**Comments by Raymond and Cheri Wagner (12175 Latigo, to the north of the area in discussion)**

**Assumptions:**

**Comments:**

Figure 9. Drainage Basins Map, data provided by Muller Engineering Company; (1988)

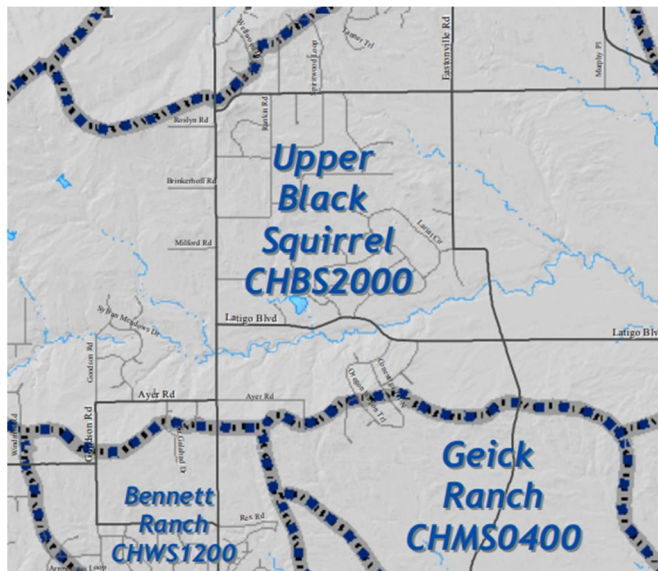
6. Surface water flows and potential flooding in the Upper Black Squirrel Creek drainage and related wetlands (for example, seasonal ponding on our property south of a feeder stream) should be addressed, particularly wrt the proposed expansion of Meridian Road to 4 lanes, and the resulting impacts of increased paving on drainage flows.

KNECHT ZONING MAP

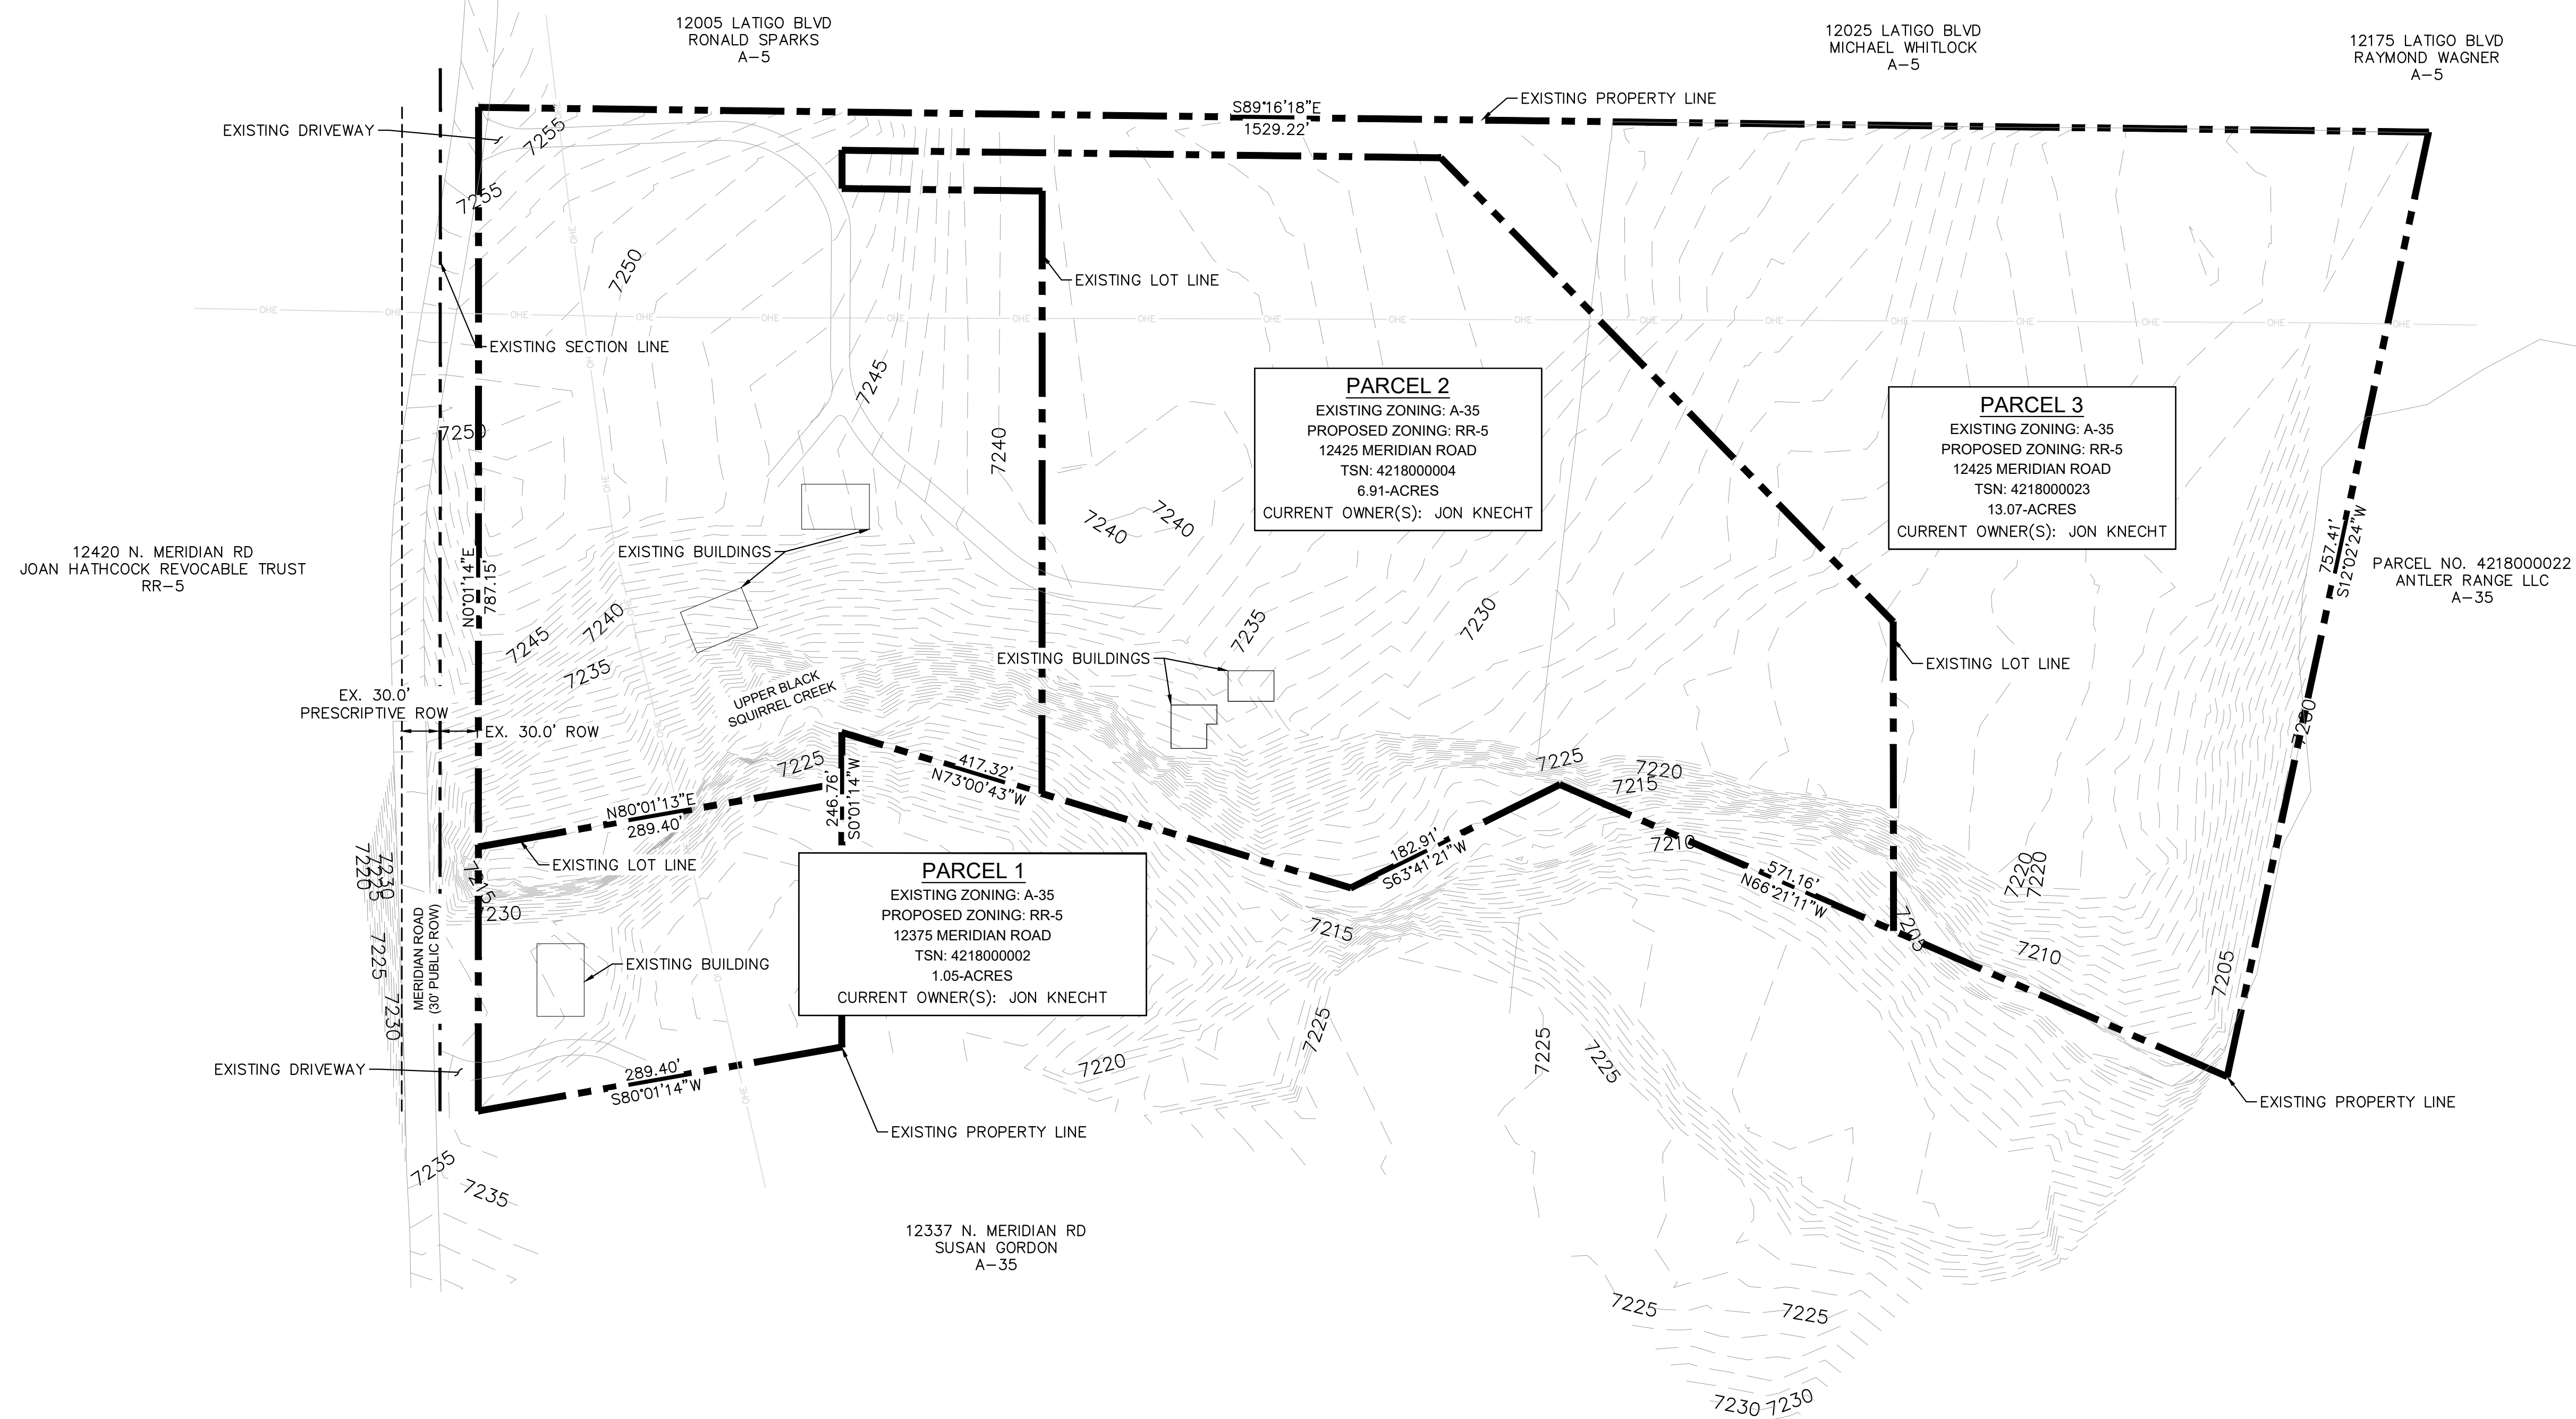
- 1. The boundaries of the 20 acre parcel that is the subject of both the Rezoning and Lot Size Variance proposals are as follows. The northern boundary of the parcel is assumed to be marked by the fence lines along the south edges of the three neighboring parcels owned, respectively, by the Sparks, Whitlocks, and Wagners. The west boundary of the parcel is the Meridian Road easement. The east boundary, based on the location of the fence line of the current cattle grazing area, runs north-south to the intersection of Ayer Road and White Antler Drive. The south boundary is Ayer Road. If this is not correct, where is the south boundary – partly through the grazing area? Who are the property owners east of the parcel and south of the 20 acre parcel? What surface (and subsurface) water rights were acquired when the property was transferred to Mr. Knecht?**

- 4. The Zone of Impact distance setting for notification seems small (only 500 ft of offset) if possible long-term impacts of future separate development of the three 5 acre lots are considered. In particular, future development of the 5 acre lots could affect aspects of the values of both adjacent and further distant neighbors' properties, such as line-of-sight visibility of Pikes Peak, wildlife proximity, drainage, and light pollution. These are a concern especially if the 5 acre lots are subdivided and also with respect to building heights and other construction rules. In particular, the offsets**

for construction under the rules for the proposed zoning seem too small wrt to the Mountain View power lines and adjacent roadways.
